SSD 5752, Sydney International Convention, Exhibition and Entertainment Precinct – Redevelopment of convention centre, exhibition centre, entertainment facilities and associated public domain works (SSD) is referred to as **PPP**

Sydney International Convention, Exhibition and Entertainment Centre Precinct – Mixed use Development in the Southern Haymarket Precinct (Concept Proposal) (SSD) is referred to as **PDA**

Figure 14: Maximum height envelope of the Haymarket precinct

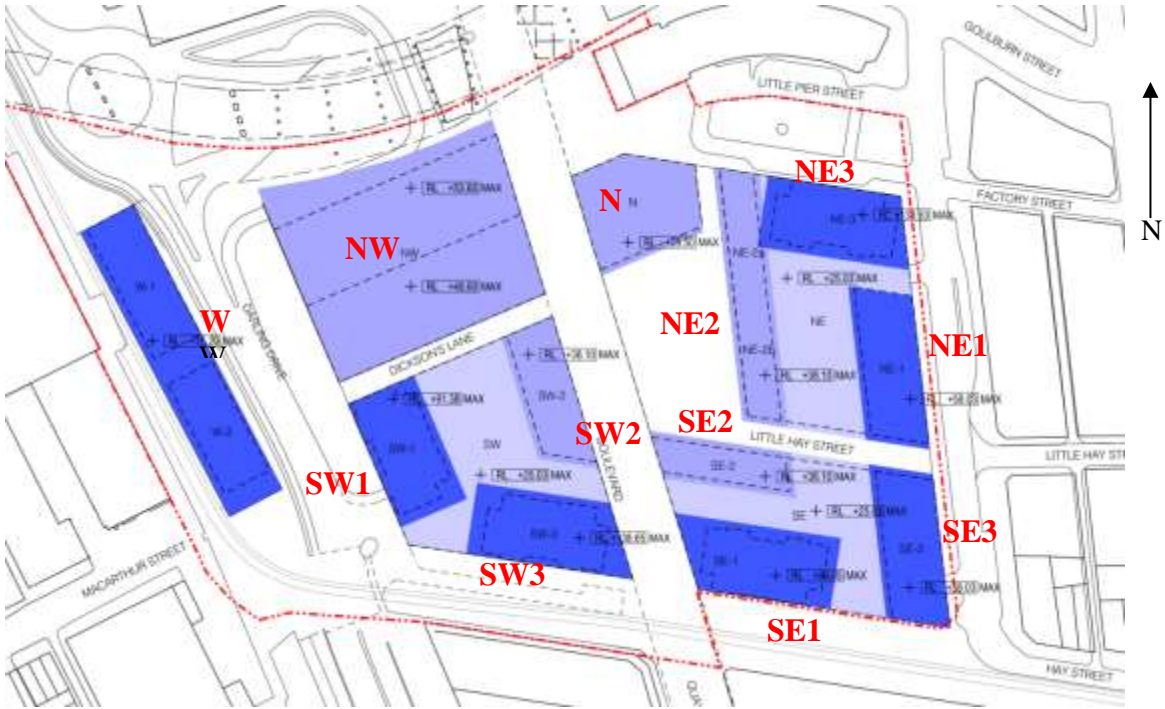
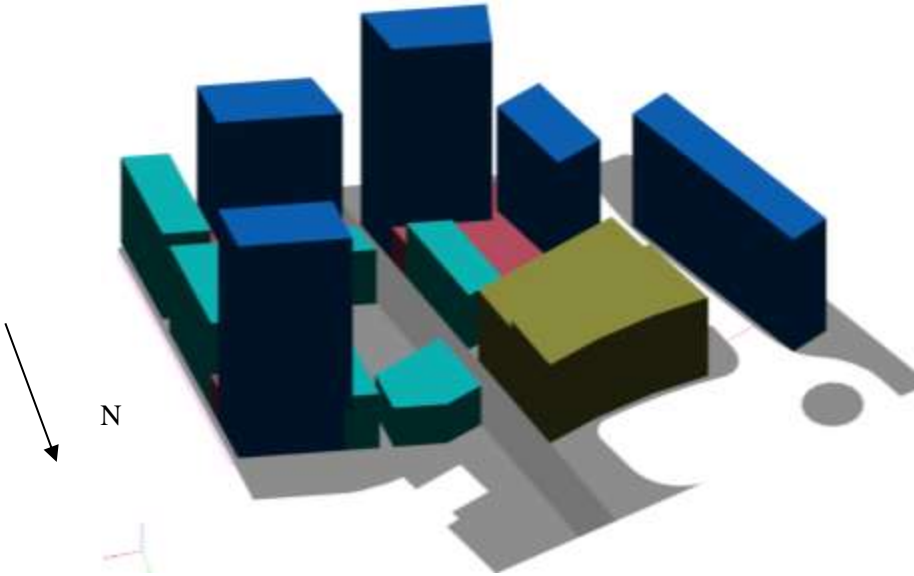
Cermak Peterka Petersen (CPP) also appear reticent in their approval. The report finds that the proposed building envelopes may result in downwash from taller buildings, and that windy conditions could be expected at ground level at the windward corners of the buildings. Channelling wind flow could also be experienced at some locations without appropriate amelioration.

It is not unreasonable to suppose that a strong southerly wind would be channelled between SE1 and SW3, howl up the boulevard and will cause a cyclonic effect in the Haymarket Square.
